Our ref: OUT22/6197

**Subject: Walla Walla Solar Farm Mod 2 - Project Layout Changes (SSD-9874-Mod-2)-
Modification Report**

Department of Planning and Environment: Water

Figure 5-1 Proposed Modification

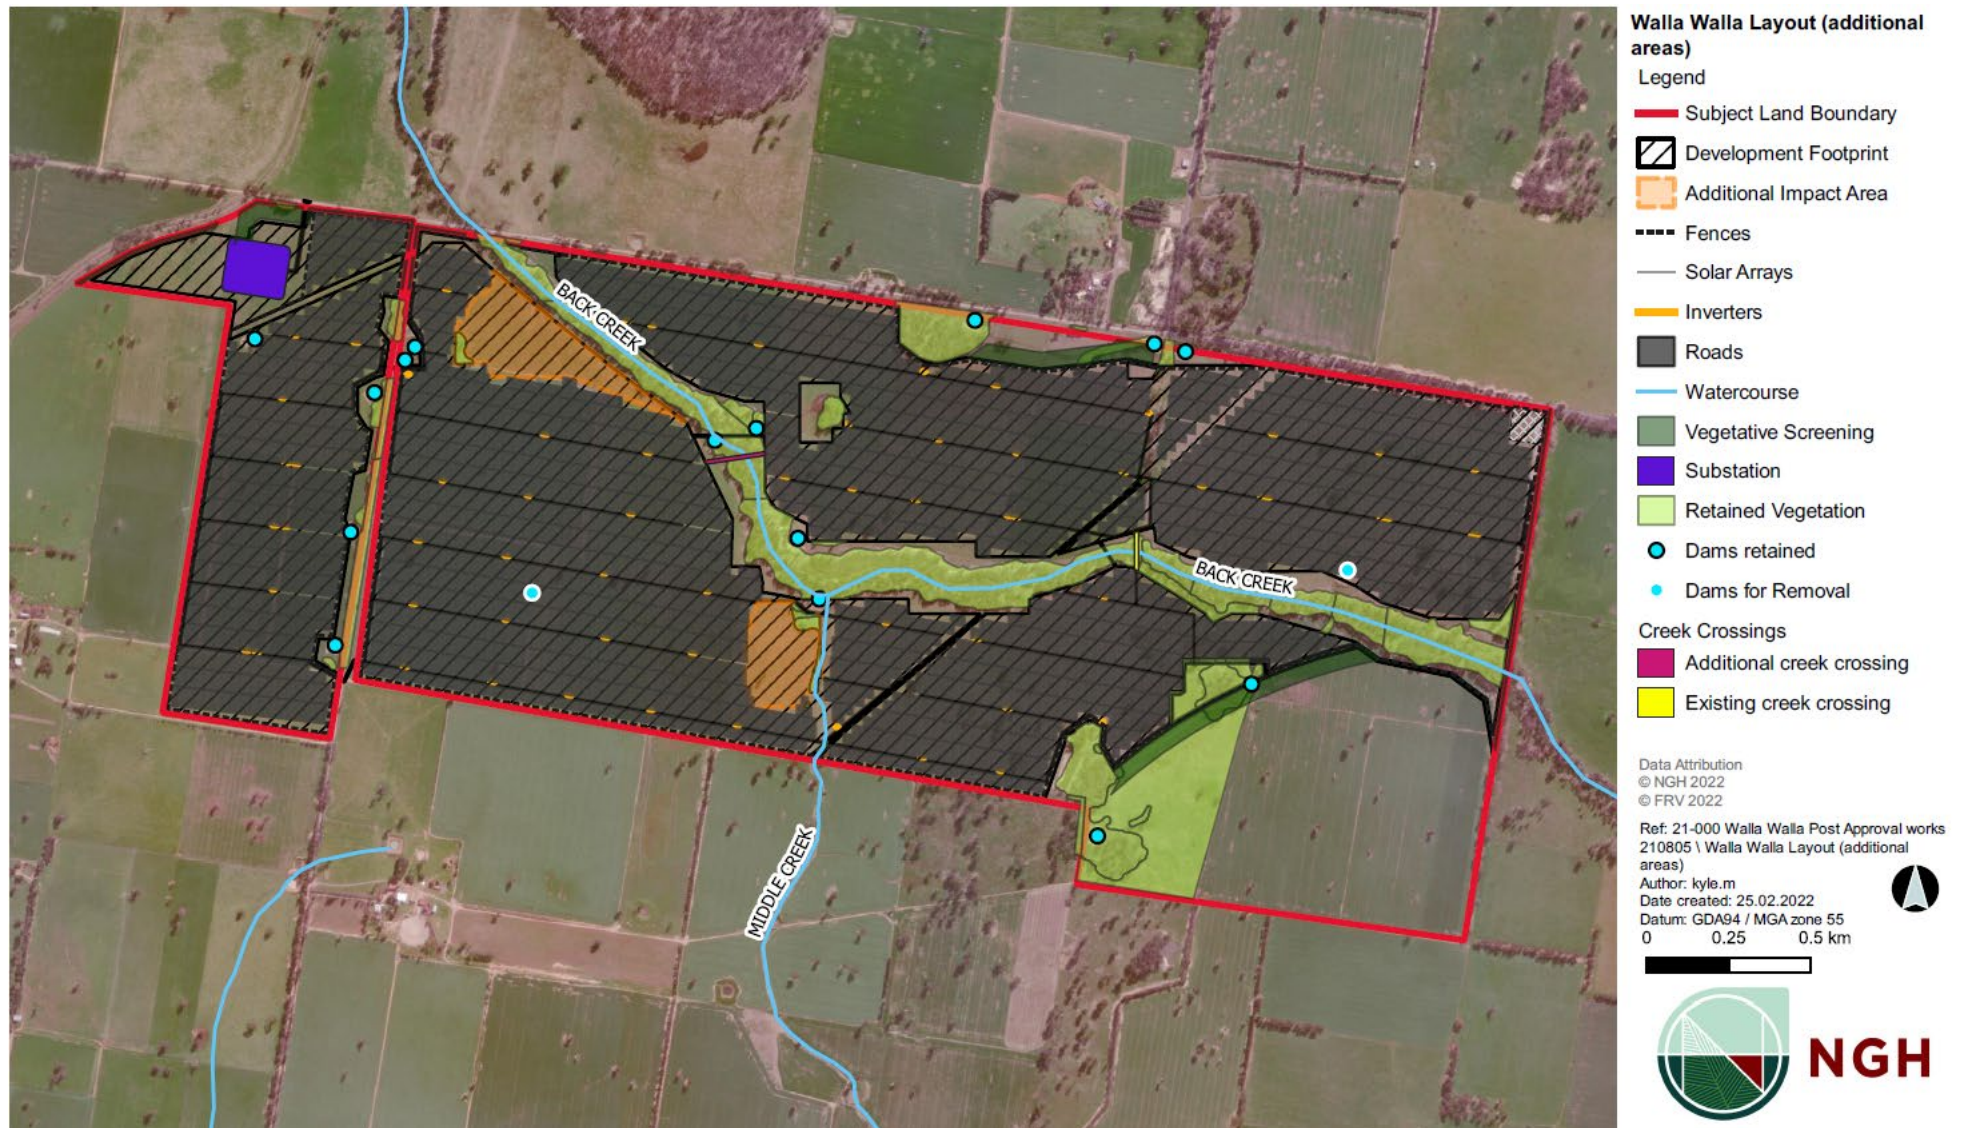
- The proponent should confirm there have been no modifications to the approved setbacks required for all watercourses on site.

DPE Water recommends that the proponent provide confirmation that there has been no changes to watercourse setbacks, and that they will be in accordance with the previously approved layout. This was 20m vegetated buffer from top of each bank for Middle Creek and 30m vegetated buffer from Back Creek.

- Works within waterfront land need to be in accordance with the Guidelines for Controlled Activities on Waterfront Land.

Works on waterfront land, including the additional watercourse crossings, should show due consideration to the Guidelines for Controlled Activities.
